LY/20/13/CLP

Recommendation Report for Lawful Development Certificate for a Proposed Use or Development

LOCATION: Almond Cottage
The Causeway
Arundel

PROPOSAL: Application for a Lawful Development Certificate for the proposed formation of front and rear dormers to existing roof, alteration of hipped to gable end on south elevation and general alterations and formation of front porch canopy on west elevation.

PROPOSED GROUND FLOOR PLAN

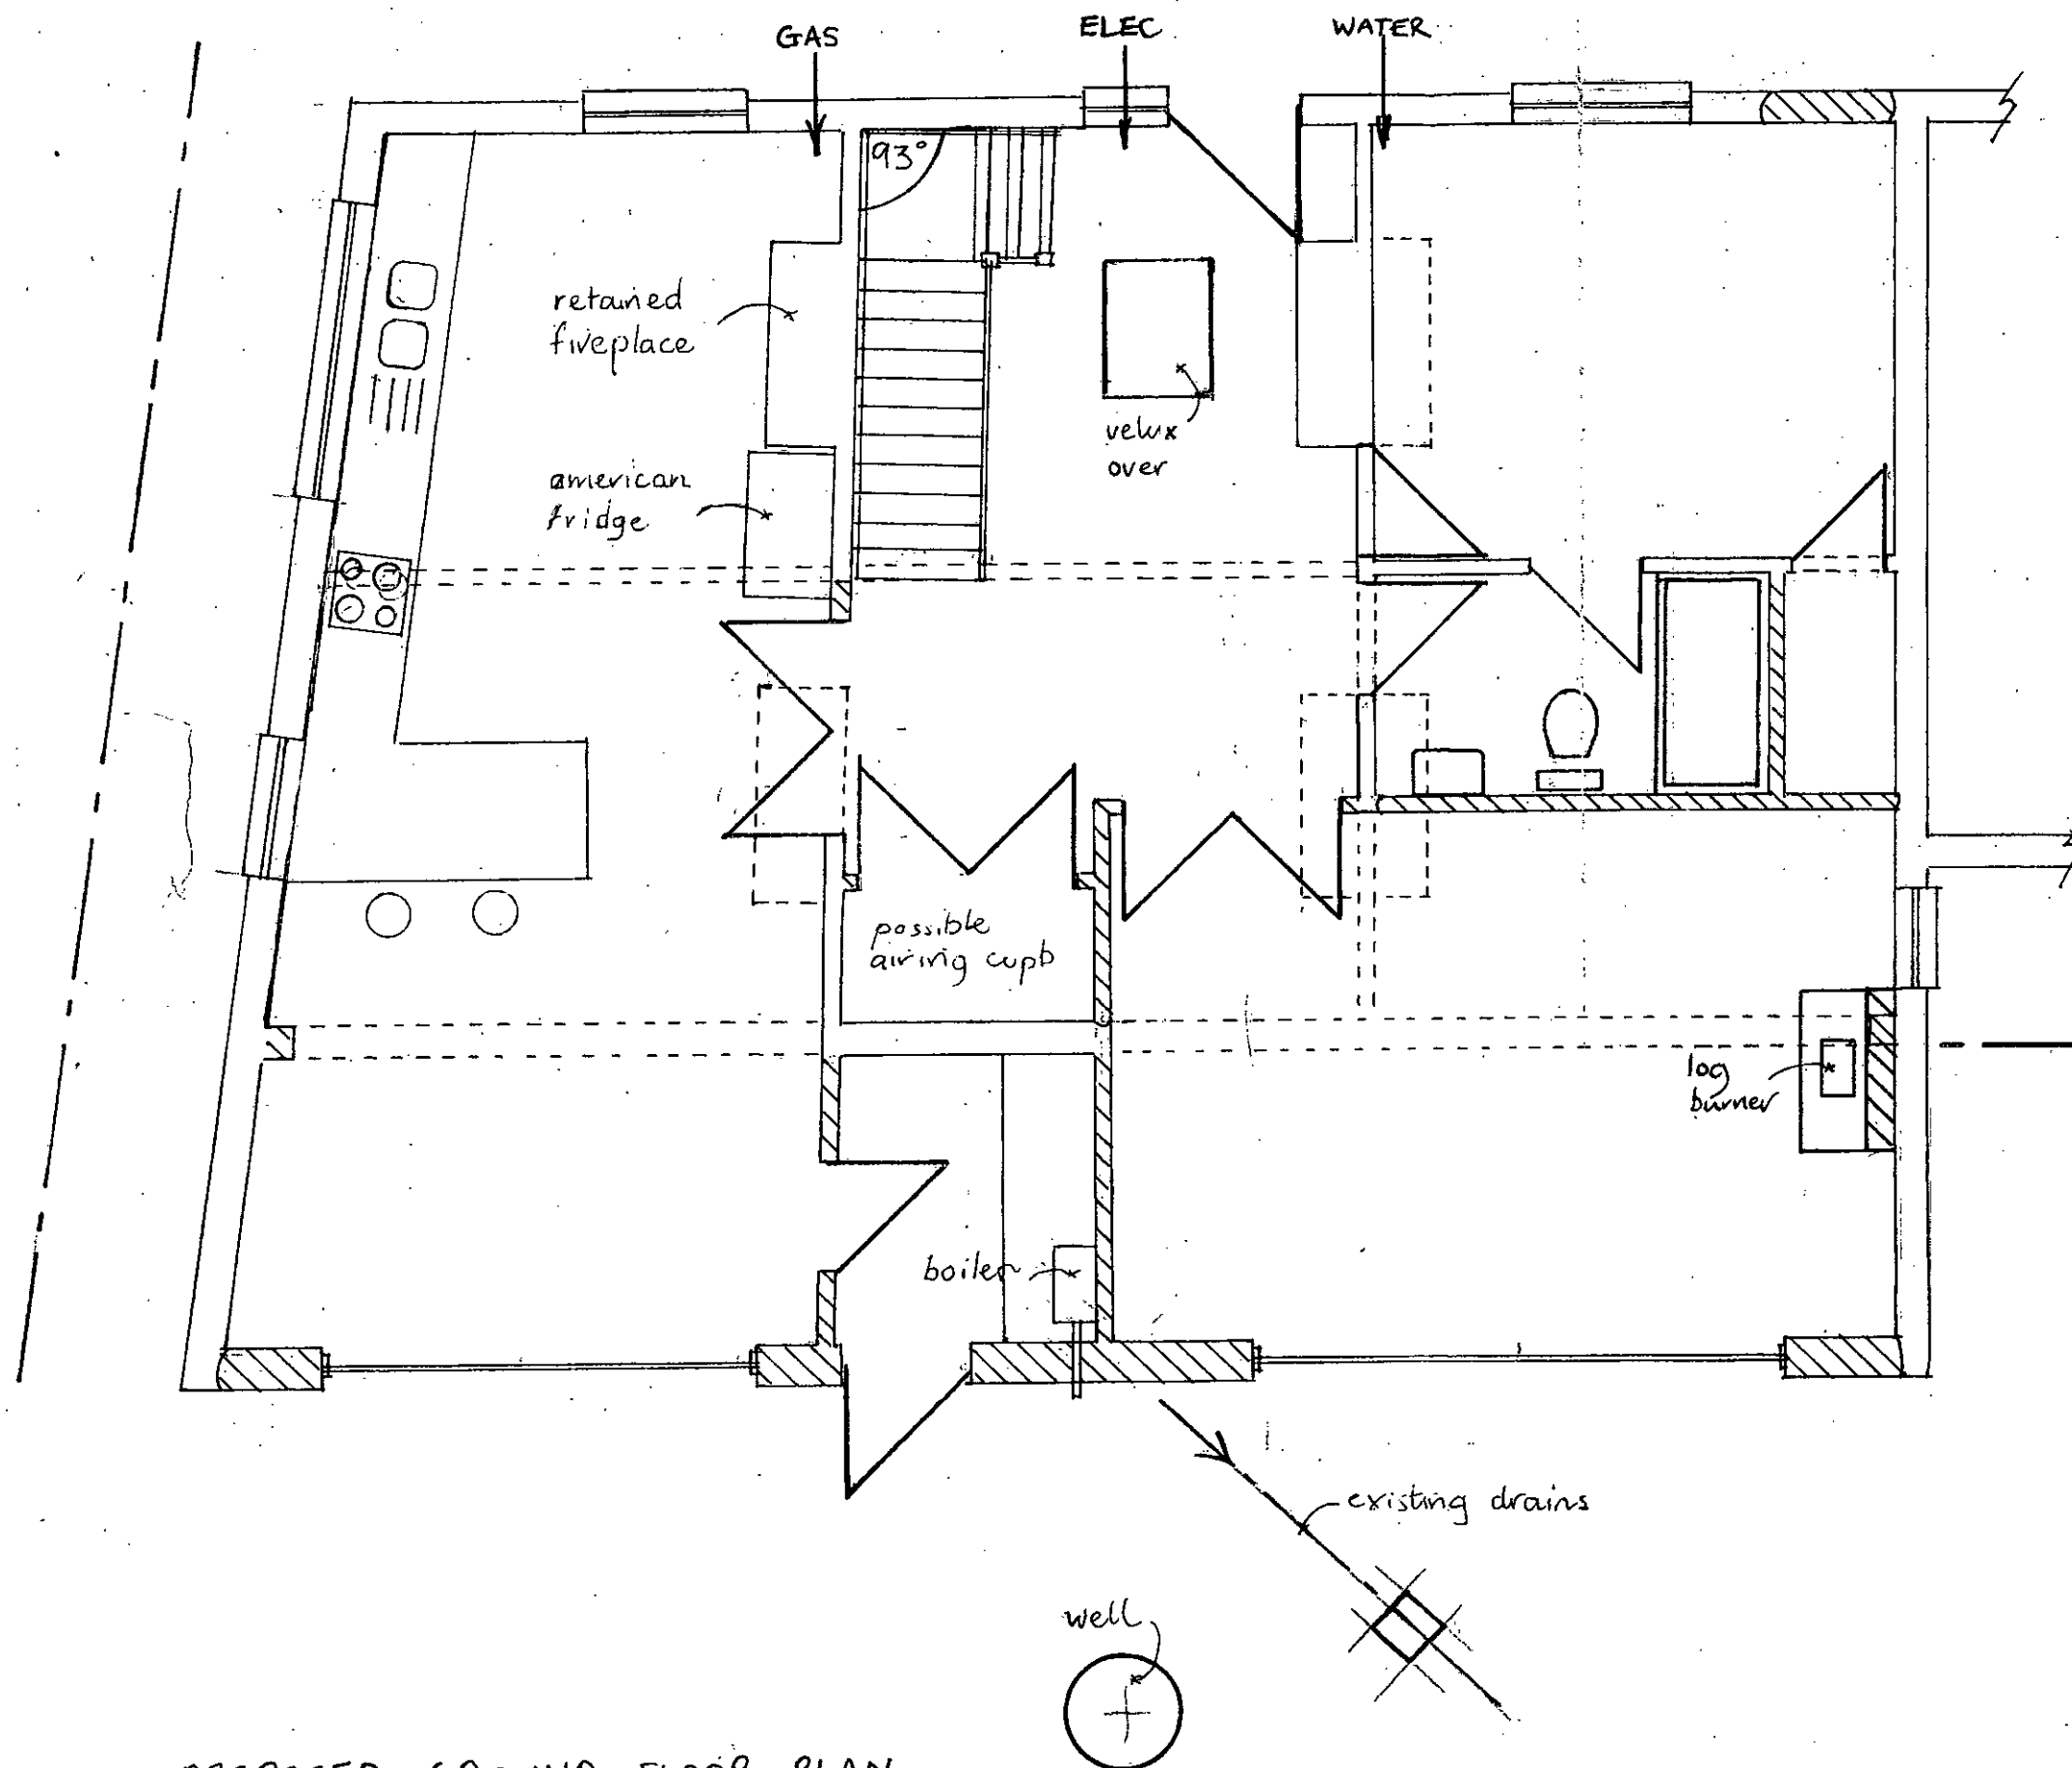
Class A (e) specifies that the extension will be single storey and not exceed 3m in length in the case of a semi-detached property. The proposed extension measures approximately 2.3m in length and so complies with this requirement.

Class A (g) refers to extensions being within 2m from the boundary of the curtilage of the dwellinghouse and the height of the eaves of the development not exceeding 3m. The eaves height for the extension is approximately 2.5m and so this criteria is met.

PROPOSED ELEVATIONS

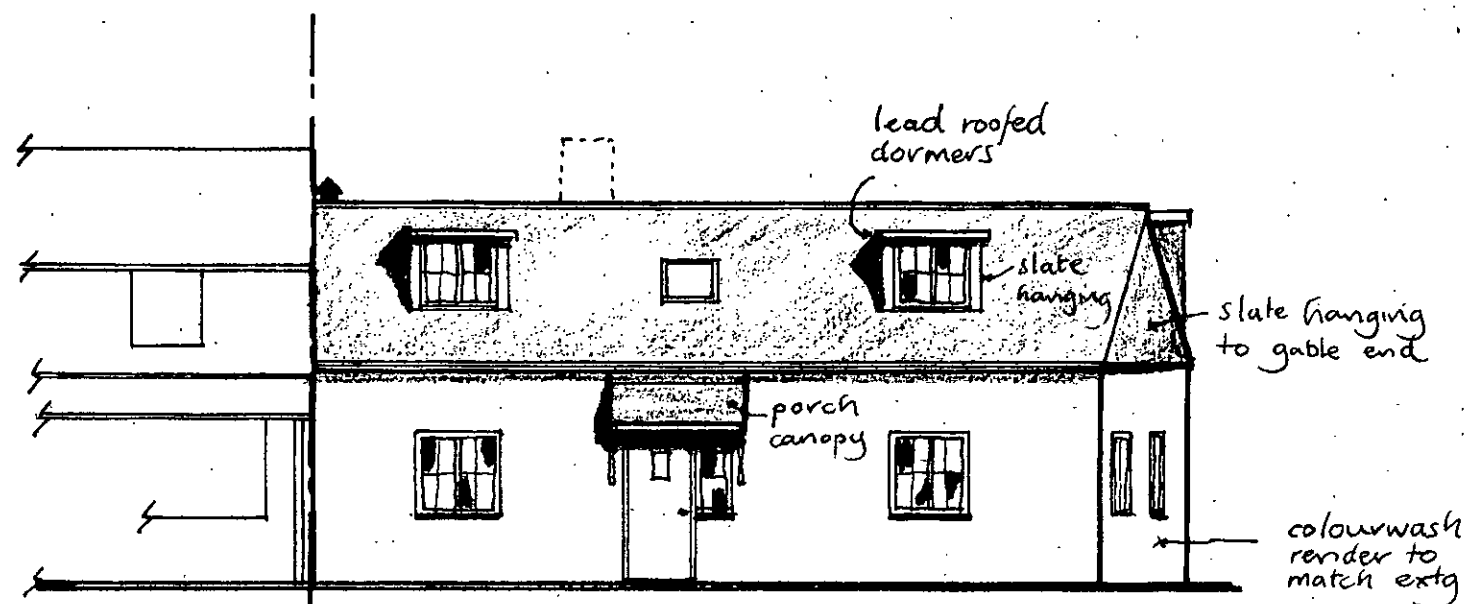
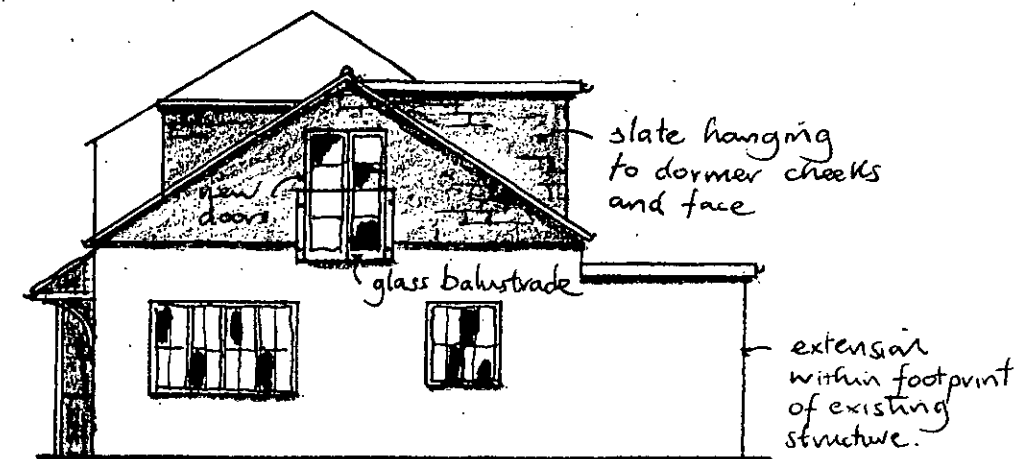
The Town and Country Planning (General Permitted Development)(Amendment)(No. 2)(England) Order 2008 Article 3 Schedule 2 Part 1 Class B (a) states that the rear dormer should not exceed the height of the existing dwelling. The dormer is lower than the main roof of the dwelling.

Class B (c) states that the dormer should not exceed the cubic content of the original roof space by more than 50 cubic metres. The rear dormer measures approximately 30.2 cubic metres and so meets this requirement.

A Condition of the build under B2(a) is that any materials used in the exterior work shall be of a similar appearance to those used in the construction of the exterior of the existing dwellinghouse. In this case, it is noted that slate hanging will be applied to the dormer face and cheeks. The property has had slate roof tiles as determined on a site visit, although these have been recently removed.

The Town and Country Planning (General Permitted Development)(Amendment)(No. 2)(England) Order 2008 Article 3 Schedule 2 Part 1 Class B (a) states that the two front dormers should not exceed the height of the existing dwelling. The dormers are lower than the main roof of the dwelling.

Class B (c) states that the dormer should not exceed the cubic content of the original roof space by more than 50 cubic metres. The front dormers combine to measure approximately 4 cubic metres and so meets this requirement. When combined with the rear dormer they measure approximately 34.24 cubic metres which again meets this criteria.

A Condition of the build under B2(a) is that any materials used in the exterior work shall be of a similar appearance to those used in the construction of the exterior of the existing dwellinghouse. In this case, it is noted that slate hanging will be applied to the dormer face and cheeks which matches existing (before slate tile removal recently).

The Town and Country Planning (General Permitted Development)(Amendment)(No. 2)(England) Order 2008 Article 3 Schedule 2 Part 1 Class B (a) states that the roof enlargement should not exceed the height of the existing dwelling. The roof enlargement is at the same height as the main roof of the dwelling and so meets this criteria.

Class B (c) states that the roof enlargement should not exceed the cubic content of the original roof space by more than 50 cubic metres. The hip to gable enlargement measures approximately 9.32 cubic metres and so fulfils this criteria.

A Condition of the build under B2(a) is that any materials used in the exterior work shall be of a similar appearance to those used in the construction of the exterior of the existing dwellinghouse. In this case, it is noted that there will be slate hanging at the gable end which matches existing materials.

Class A (b) refers to development not exceeding the highest part of the existing roof. The doors and balustrade are set below this point to meet this criteria.

Class A (i) states that the development should not include (i) the construction or provision of a veranda, balcony or raised platform. The glass balustrade is not considered to be a balcony due to its lack of depth, or for that matter, veranda or raised platform and therefore complies with this requirement.

Class A (d) states that development should not extend beyond a wall which (i) fronts a highway and (ii) forms either the principal elevation or a side elevation of the original dwellinghouse. The porch canopy is on the principal elevation of the house but does not front a highway, as confirmed by legal opinion on the matter.

Under Conditions of the build, A3(a) states that the materials used in any exterior work shall be of a similar appearance to those used in the dwellinghouse. Since the proposed materials are not specified in the application, it is not possible to say whether this Condition has been met.

However, the main criteria have been satisfied and so the porch canopy is regarded as "Permitted Development" but the applicant is advised to ensure that materials will match existing.
